From:
To: transportinfrastructure@dtf.gov.uk
Cc: [M25 Junction 10; ni.mail.distribution@notifications.service.gov.uk](mailto:M25_Junction_10_ni.mail.distribution@notifications.service.gov.uk)
Subject: MACATEER - NEW FARM - M25 Junction 10 / A3 Wisley Interchange Improvement Plan
Date: 18 November 2020 14:52:35

M25 Junction 10/A3 Wisley Interchange Improvement Plan

Our comment is that we object to the compulsory acquisition of the land including 7/11a and 7/12 to provide an access road, **if** it is to be of an inadequate width to accommodate the number of identified users and in our opinion the level of potential use is such that it is required to be two carriages along its length from the main highway.

Appendix 1: Indicative plans discussed at meetings on 24 February 2020

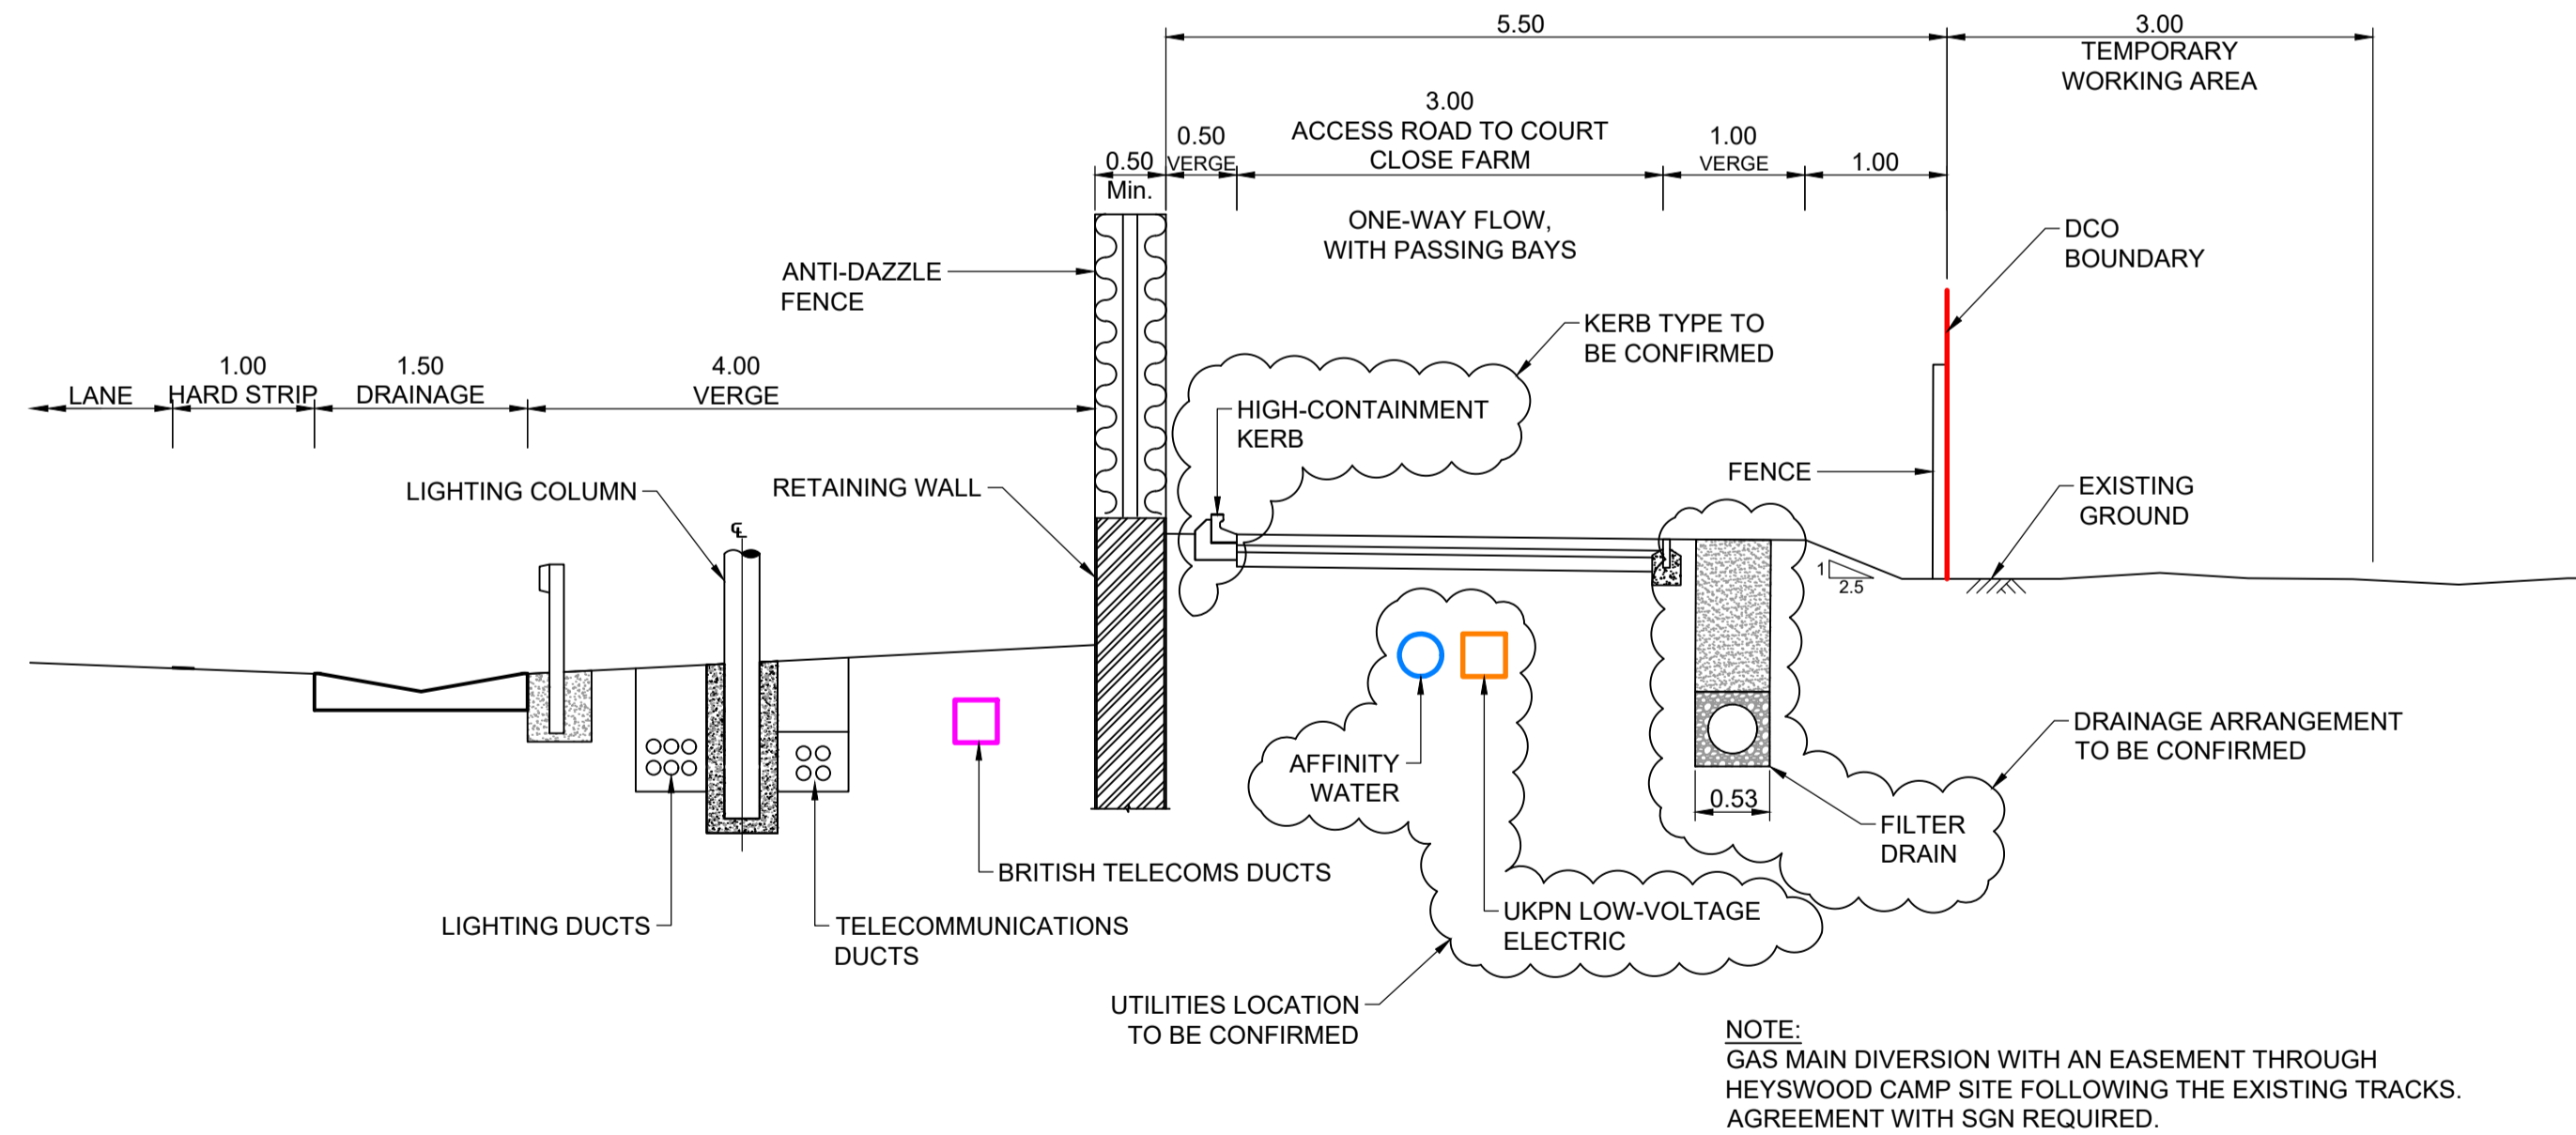
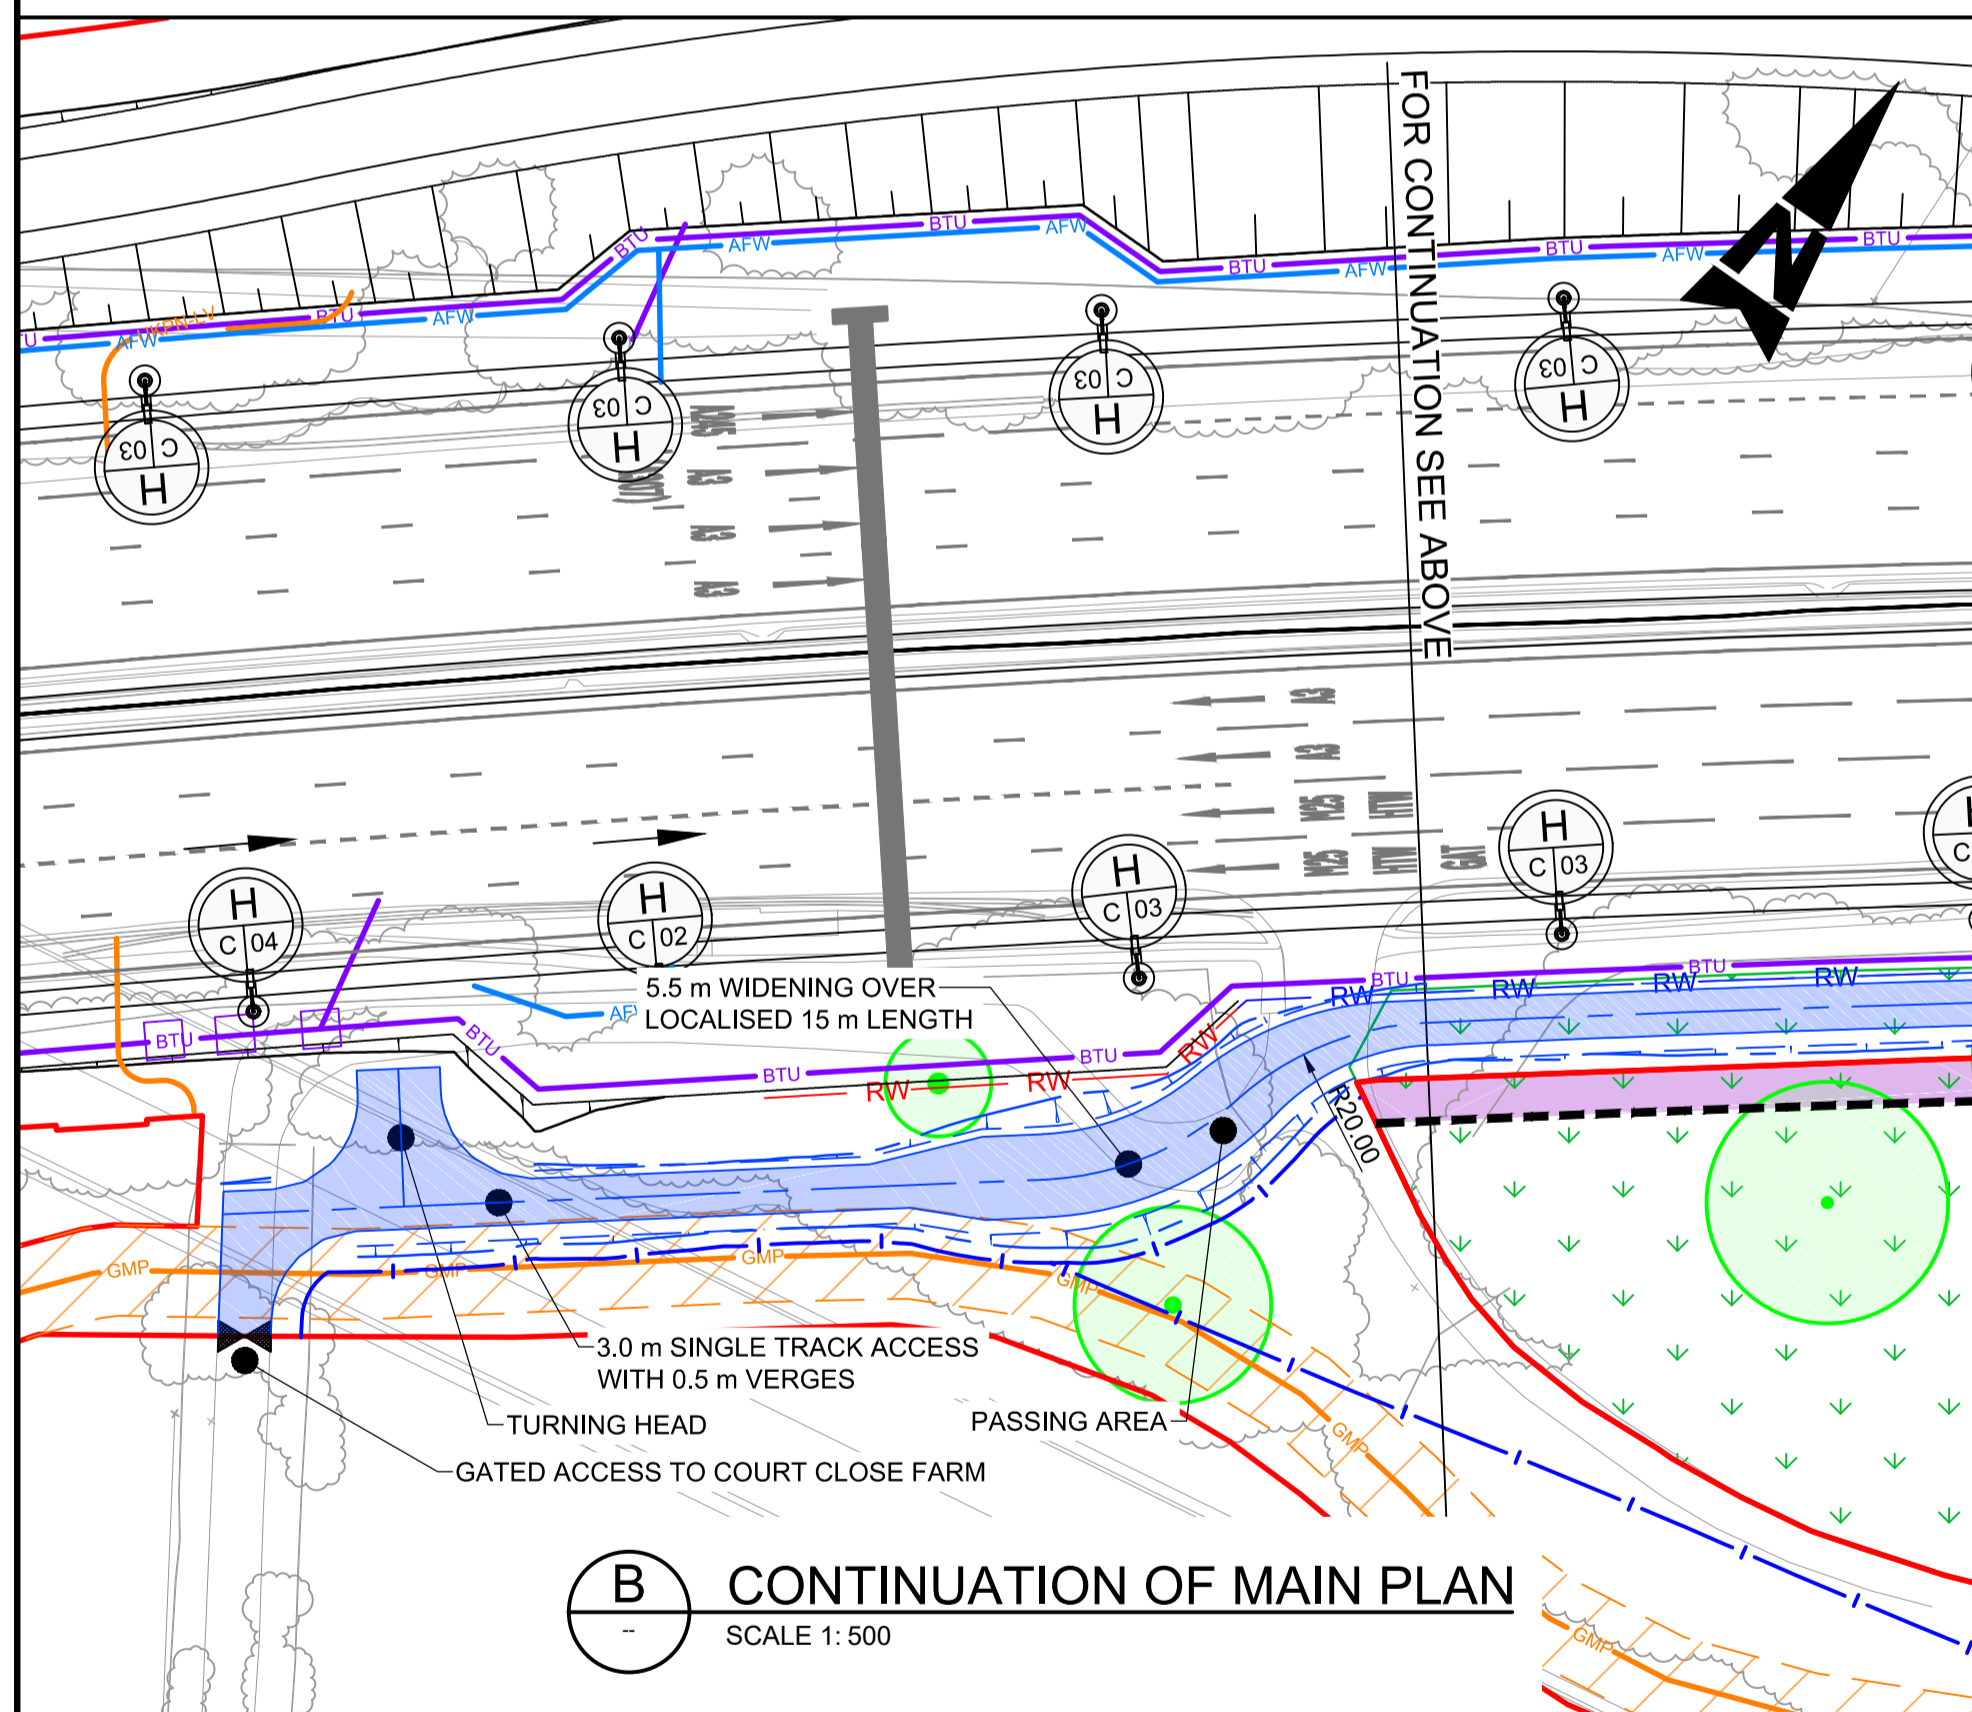
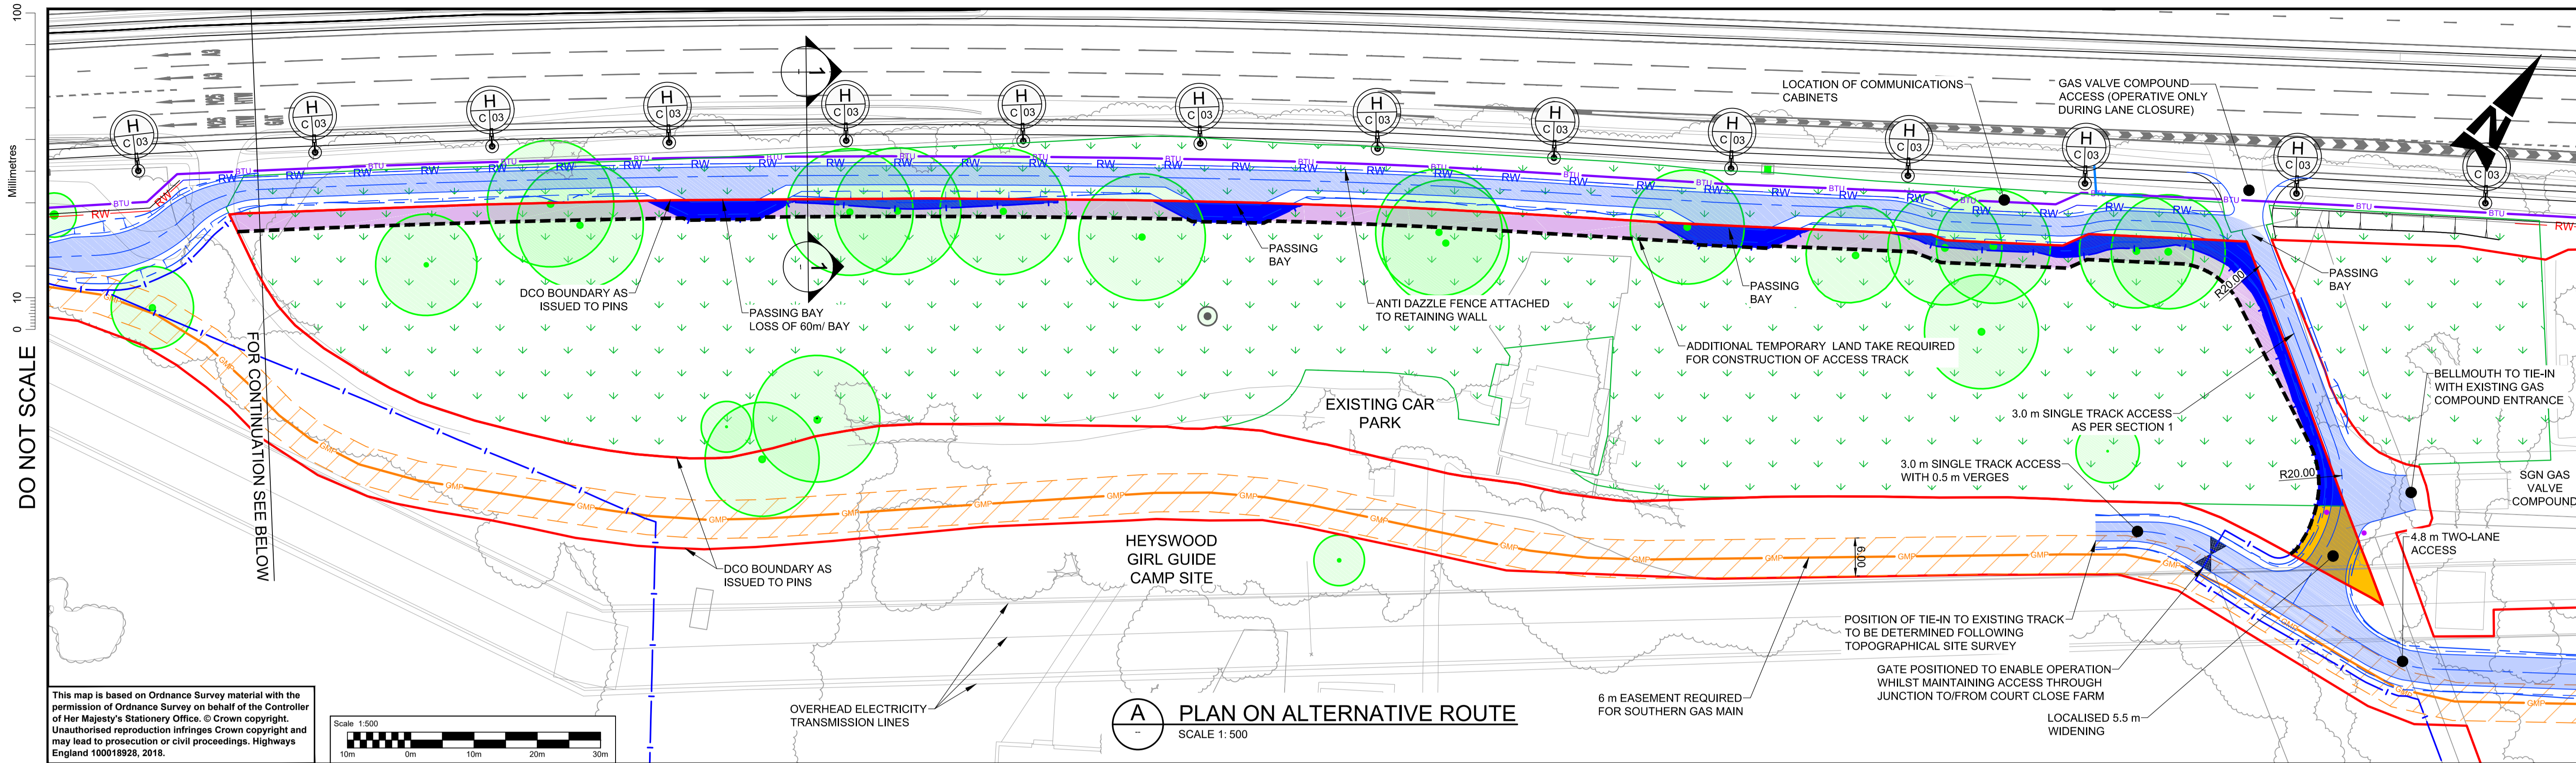
Comments under Deadlines 11 and 12 have been made that the road does not need to be as wide as has been shown on the plans and that a section of that access road can be reduced to 3m with passing bays, with presumably the remainder (from the HE comments below) being 4.8m wide with passing bays. If the access road is to be constructed, it must be of a sufficient width to prevent both accident and congestion and that cannot be less than a complete carriageway in each direction.

The spur serving only Court Close Farm can certainly be narrower if the level of use is low enough and that is not a matter for us, but the entire access road from the main road going East needs to be two carriageways and therefore even the proposed width of 4.8m with passing bays is insufficient to cater for all the users identified.

*2.2.1 As set out in Applicant's note for Action Point 2 (Session 2 Part 1 Heyswood Camp Site) [REP11-010] in response to point 2a, **the access road to the campsite car park needs to be 4.8m wide. This is to accommodate the levels of traffic using the access road to the campsite and Court Close Farm. GGLW's Post-hearing submissions including written summaries of oral case and comments on D2 submissions [REP3-061] indicated just under 10,000 vehicles visited the campsite in 2019. The carriageway also needs to accommodate large vehicles such as coaches and refuse vehicles passing in opposite directions from time to time.***

2.2.2 As there will be much less traffic using the access road between the campsite car park and Court Close Farm, Highways England can confirm that it is content to construct a 3 metre wide access road with passing places, between the campsite car park and Court Close Farm. This is subject to agreement with the owner of Court Close Farm. In the event that a 3 metre wide road is constructed, Highways England would therefore have more flexibility in reducing the land-take within this land parcel in respect of the land needed for the private access road, where this is practicable.
